Ref Planning Application R/94/19/PL

I write to record my concerned objections to the proposed changes to Block F, of the Rustington Convalescence Home Development. Within the changes detailed in this subsequent revision to the agreed and passed original scheme for the Convalescence Home.

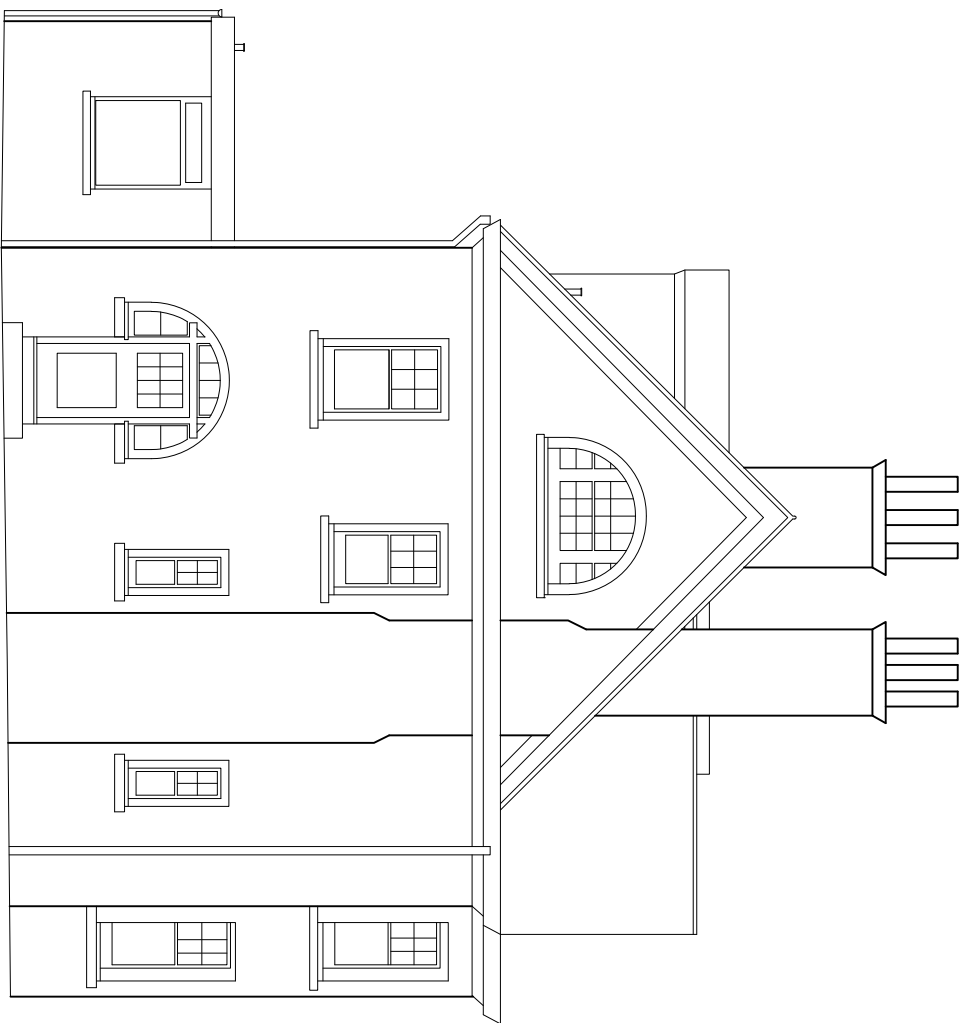
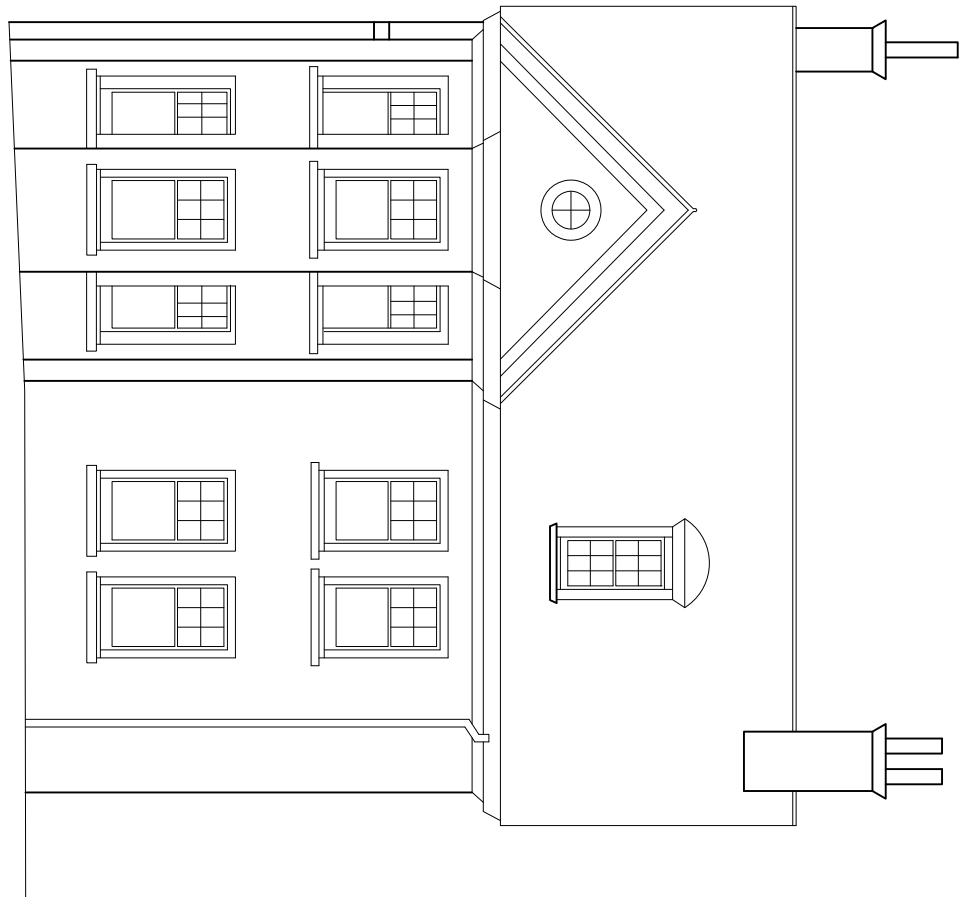
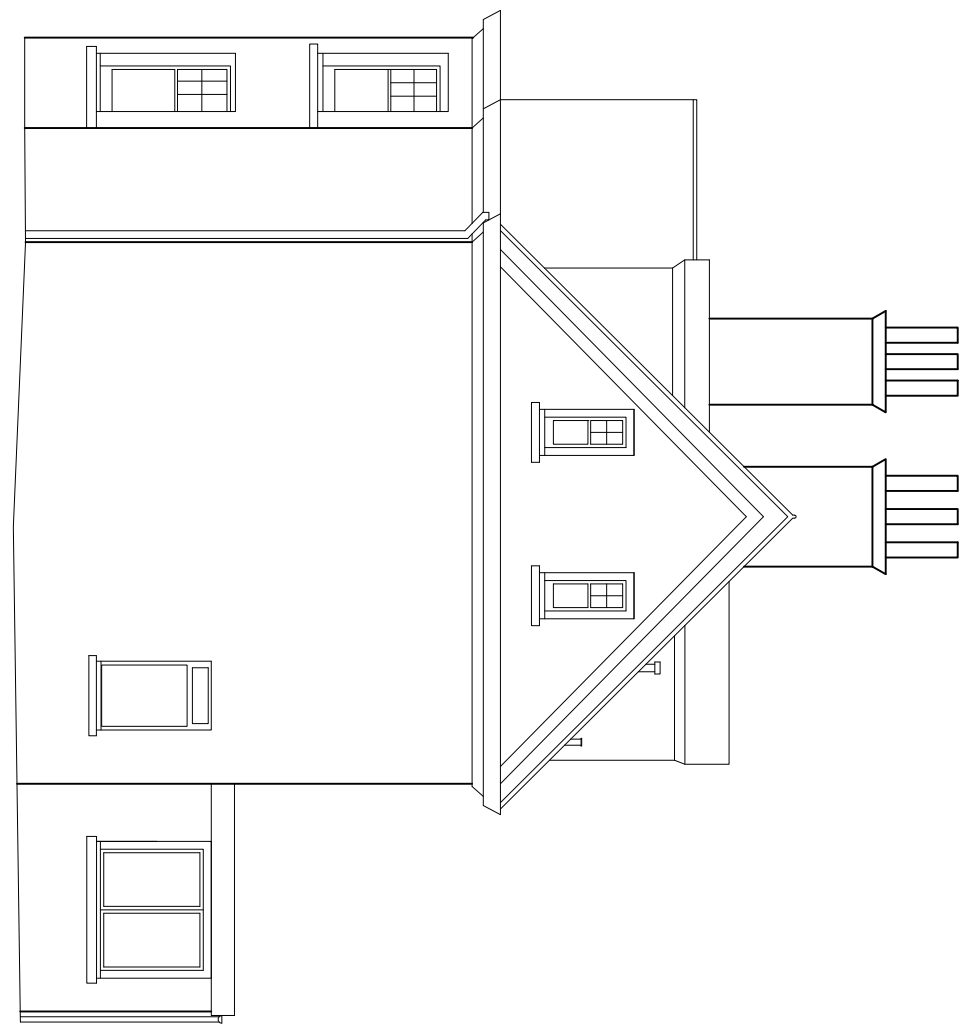
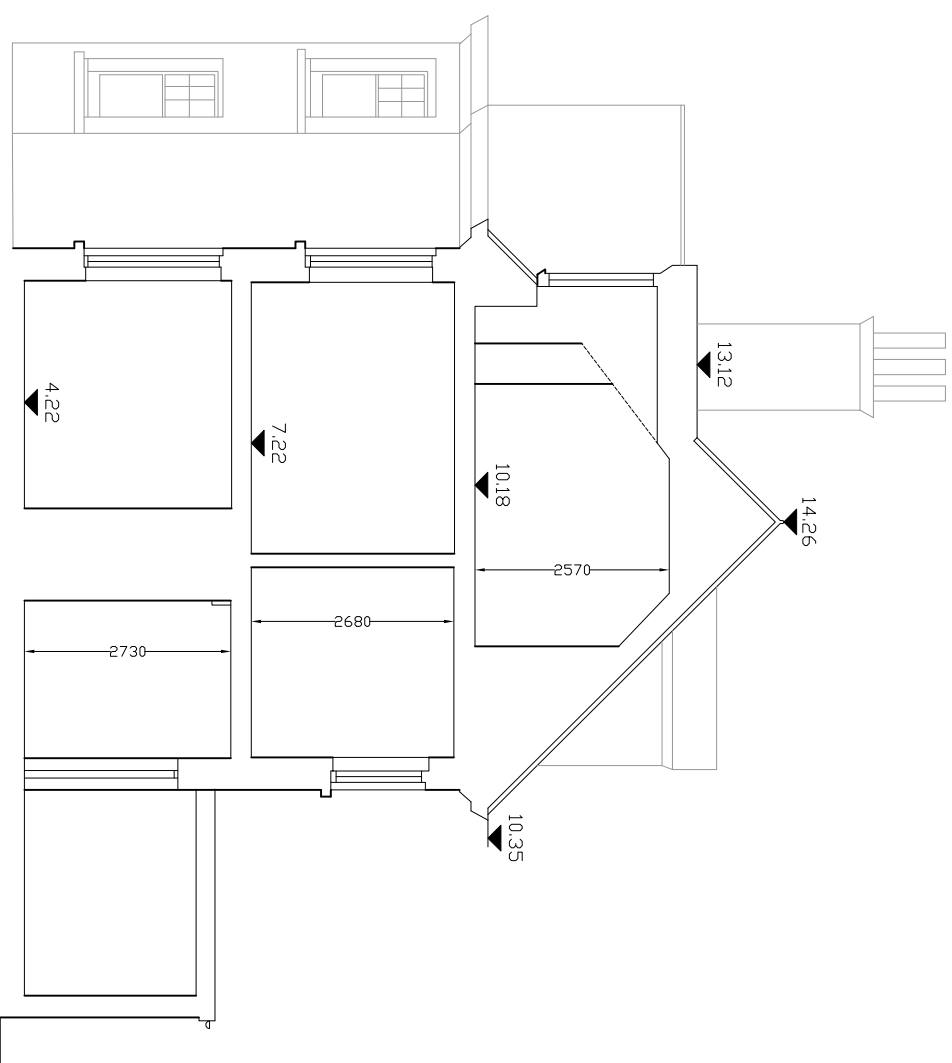
The original plans and elevations of the 2 Semi detached properties, of Block F showed them as being of a 2 Bedroom Chalet design with brickwork to the 1st floor level and the upstairs bedrooms & bathroom being contained within the roof. The design clearly shows dormer windows to the South facing bedrooms and a sloping sky light to the bathroom on the North elevation. Thus retaining the privacy of adjacent homes.

The proposed changes to the much larger 3 Bedroom houses are a complete betrayal of any consideration of the effect this would have on the existing properties to the North and East of these proposed dwellings. The changes are a blatant over development of these very small plots and would dominate the area in front of numbers 32,30,28 & 26 The Martlets. They would also over shadow the side of number 34 The Martlets as it is planned to have a very high brick gable wall to the side elevation. The plans show that with windows to the 1st floor rooms, all of the existing properties will be overlooked to the North & East elevations.

These proposed changes are a complete divergence from the original Cottage style homes of the scheme. There has been no attempt to produce anything to match in or enhance the existing adjacent properties and is a blatant over development of this part of the site.
